**Re: Galles Chevrolet Parking at 2001 Candelaria Rd. NE & Motel 1 Demo
Erosion and Sediment Control Plan
Engineer's Stamp Date 5/15/2023 (H15E007)**

Based upon the information provided in your submittal received 5/16/2023, the above-referenced ESC Plan cannot be approved until the following comments are addressed.

Schedule/ Sequencing of Construction – Motel 1

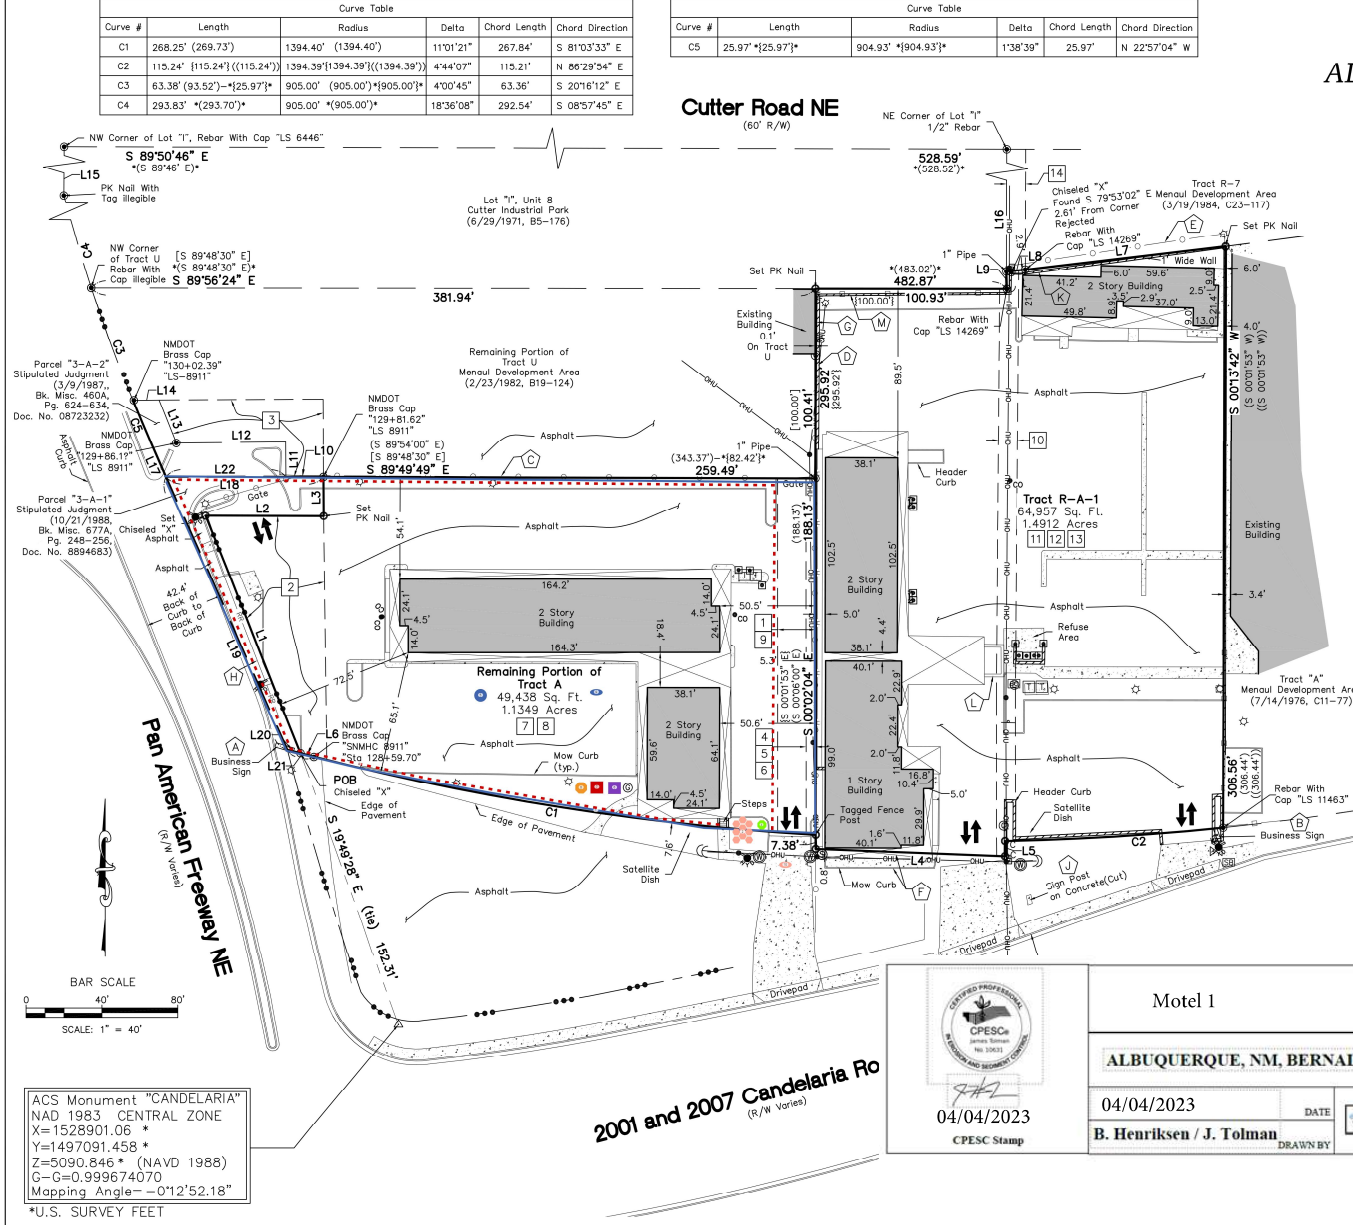
1. Item 6 of the schedule on sheet 6 says "Stabilization and Punchlist". Then a footnote at the bottom of sheet 6 says "Coronado Wrecking is responsible for only the demolition and stabilization of the site". You must specify what stabilization Coronado Wrecking will be providing and when? The ESC Plan must include site-specific interim and permanent stabilization per CGP 9.6.1.c.i. Provide specifications on the ESC Plan in accordance with CGP 7.2.6.b.vi. You must include the following:

- a. The specific vegetative and/or non-vegetative practices that will be used;
 - b. The stabilization deadline that will be met in accordance with Part 2.2.14.a.i-ii;

- c. The beginning and ending dates of the seasonally dry period and the schedule you will follow for initiating and completing vegetative stabilization; along with schedules for implementation per CGP 2.2.14.
